CITY OF ALBUQUERQUE

**RE: Mesa Del Sol Self Storage
5500 Turing Dr. SE
Grading and Drainage Plan
Engineer's Stamp Date: 01/15/2025
Hydrology File: R16DA1004**

Based upon the information provided in your submittal received 02/07/2025, the Grading & Drainage Plan is approved for the **Foundation Permit**. The following conditions need to be addressed prior to approval of Building Permit:

CIVIL DETAILS.

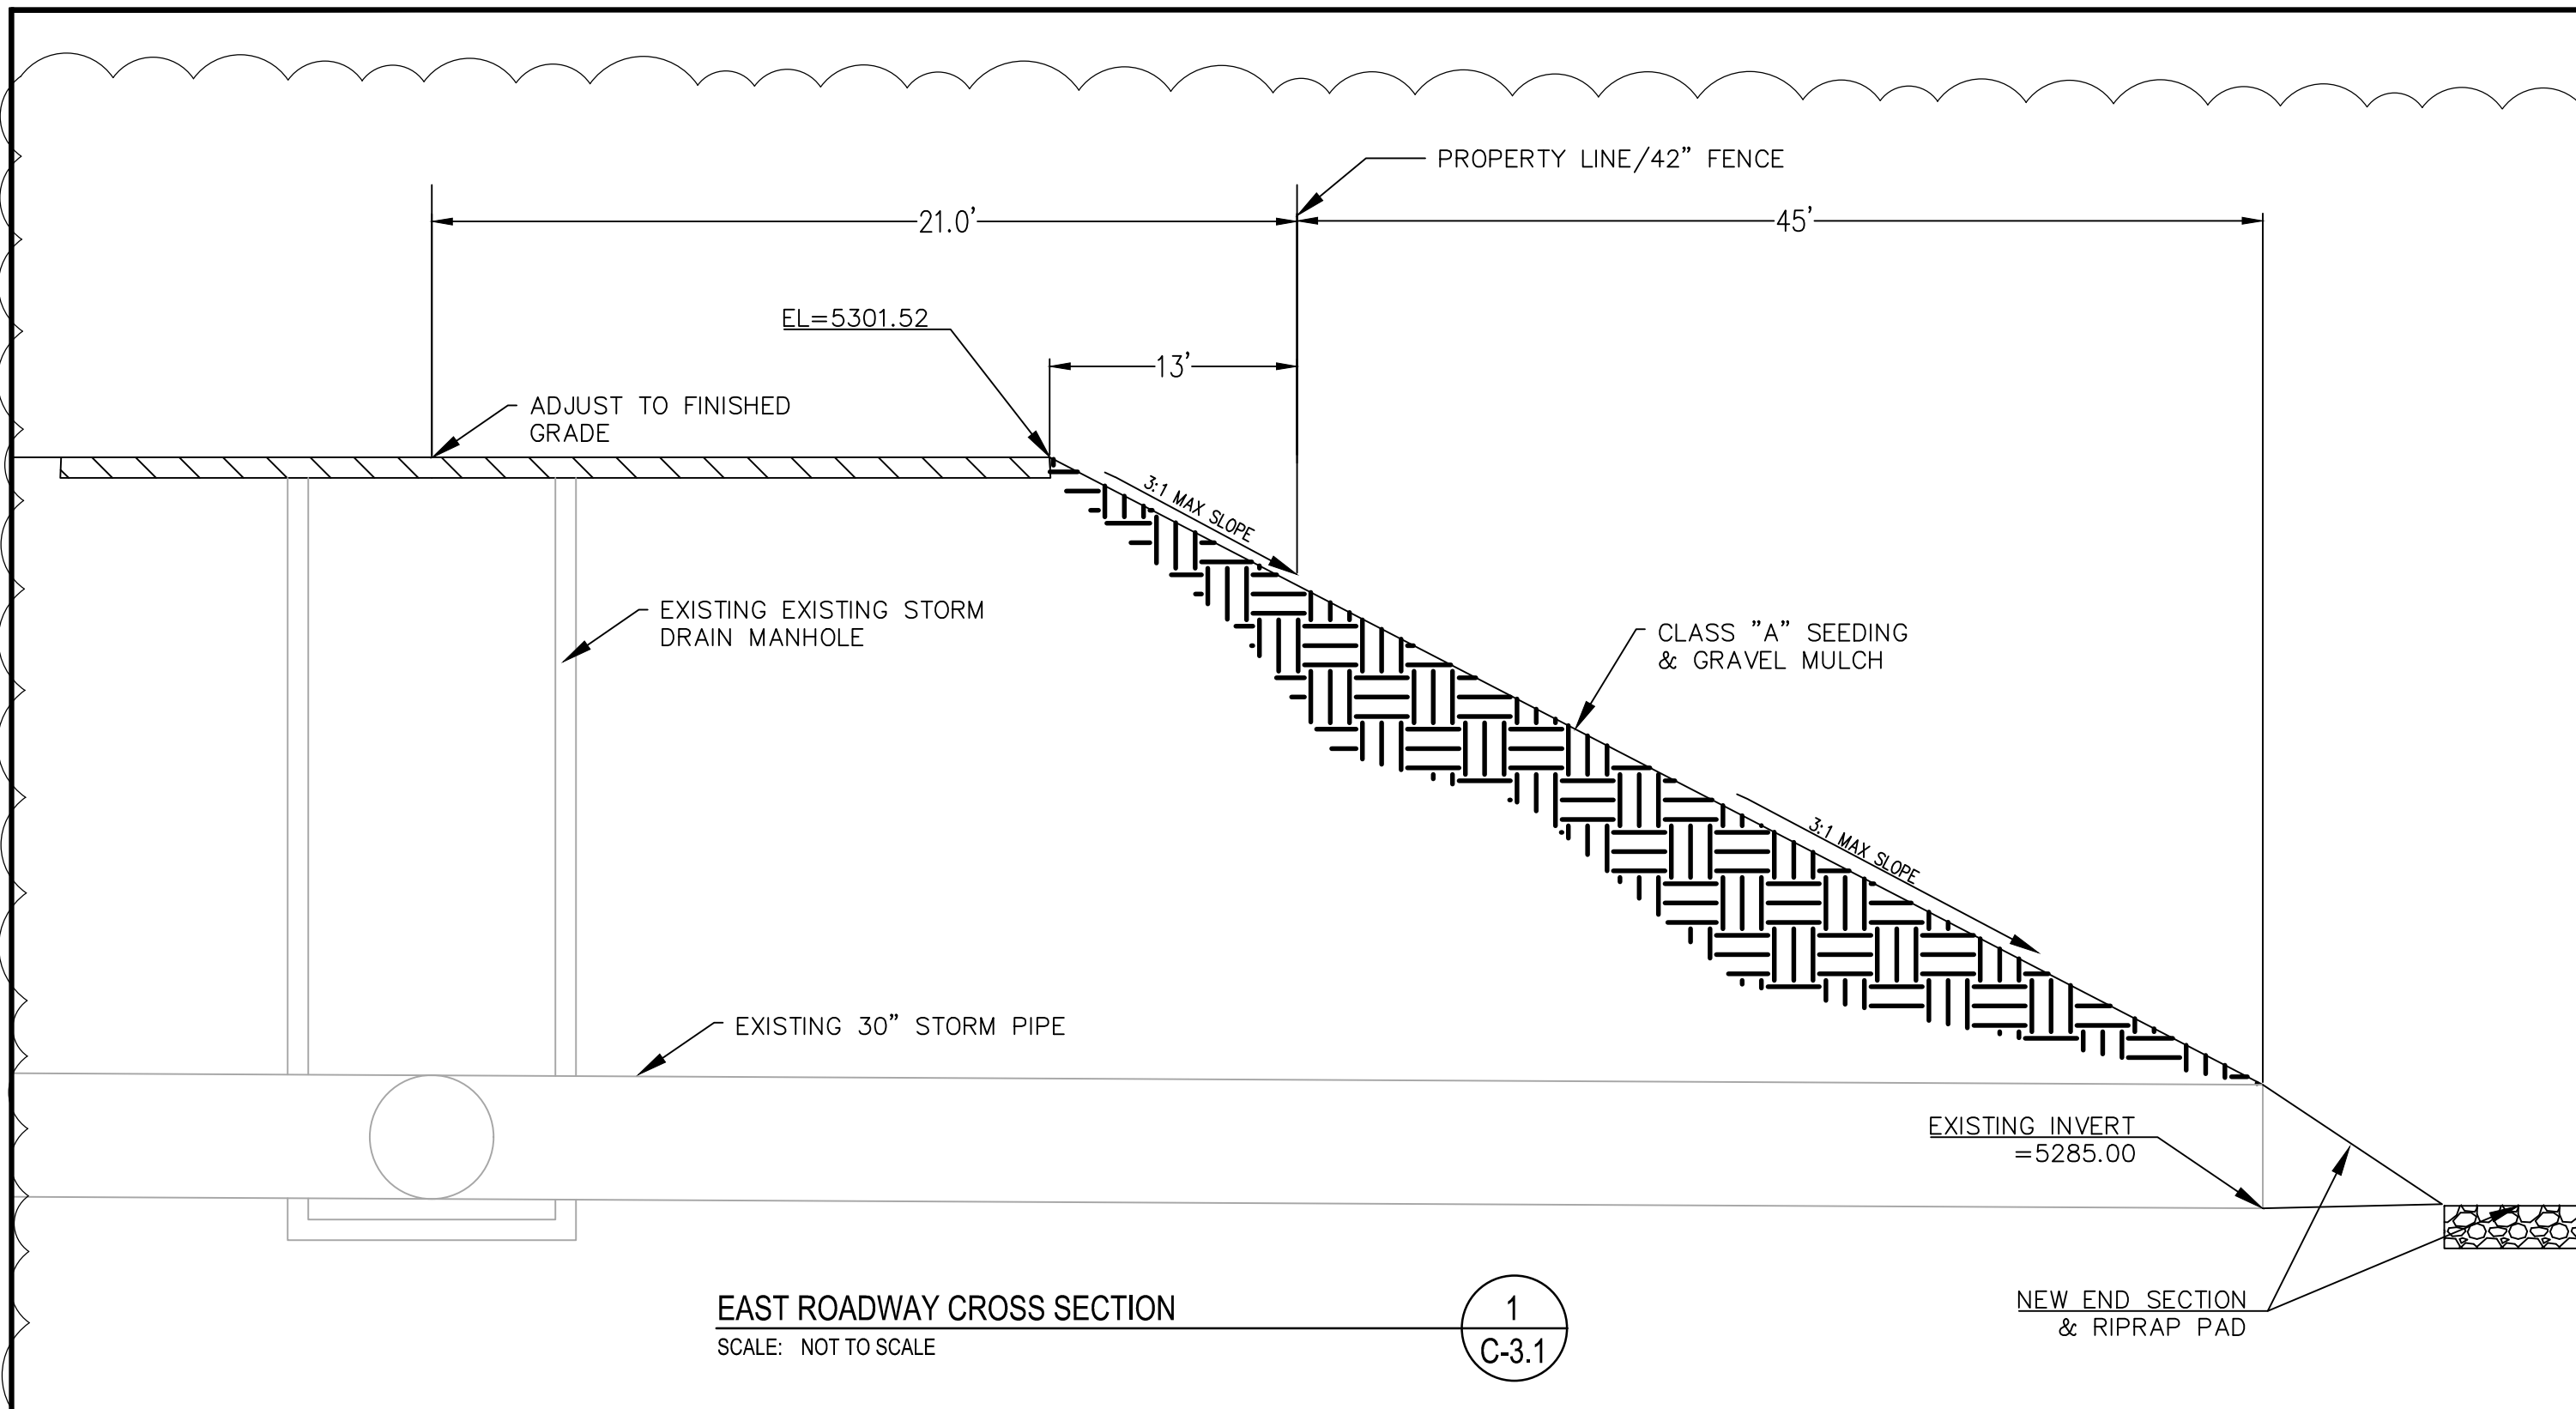
2. Due to the proposed retaining wall in Section 1 of C-3.1, provide an additional cross-section showing the existing storm drain manhole and pipe extension through the proposed retaining wall and into the retention basin at the southeast corner of the project.

SHEET NUMBER: **C-1.0**

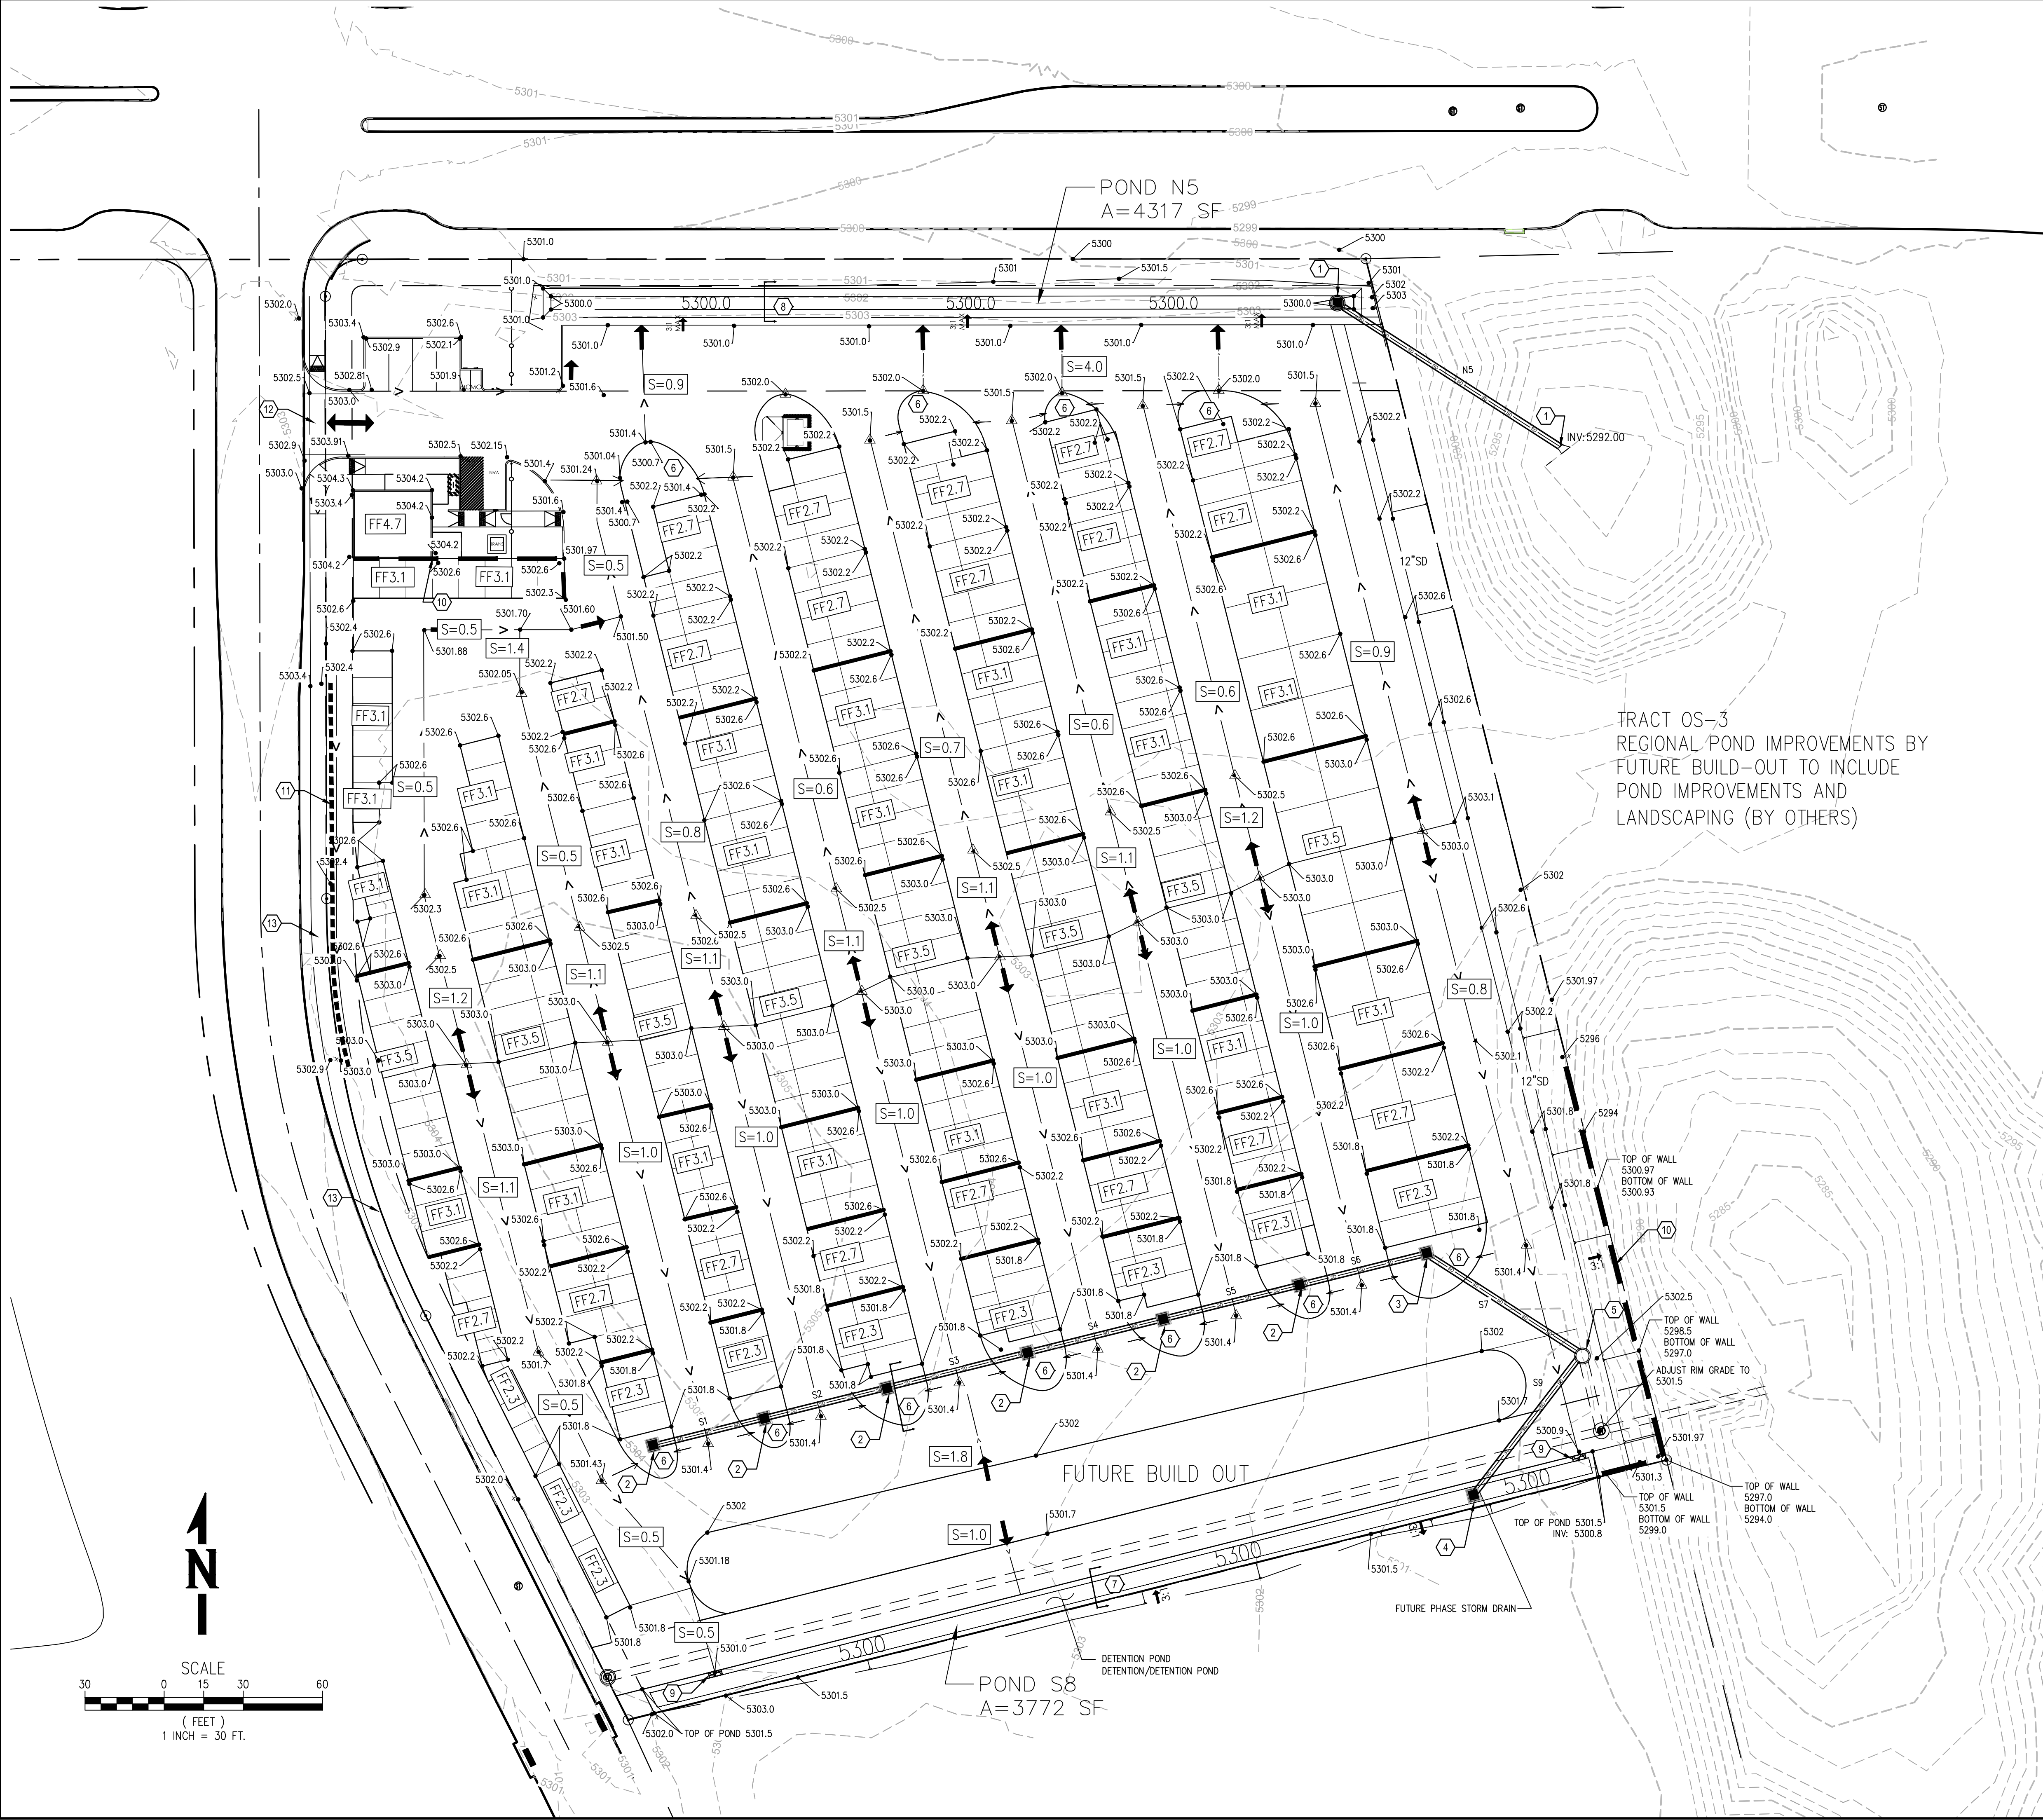
3. Provide sections through all external boundaries showing proposed retaining walls, garden walls, property/ROW lines, existing and proposed grades. In accordance with DPM Ch.22, section 5, part B. Grading and wall construction near the property line may not endanger or encroach upon adjacent property or constrain its use.

4. Show all portions of proposed retaining walls on the property of the project.
5. The existing ponds should be completely developed for the 100-year 10-day storm and associated capacity, together with slope erosion protection and access barricades where needed.
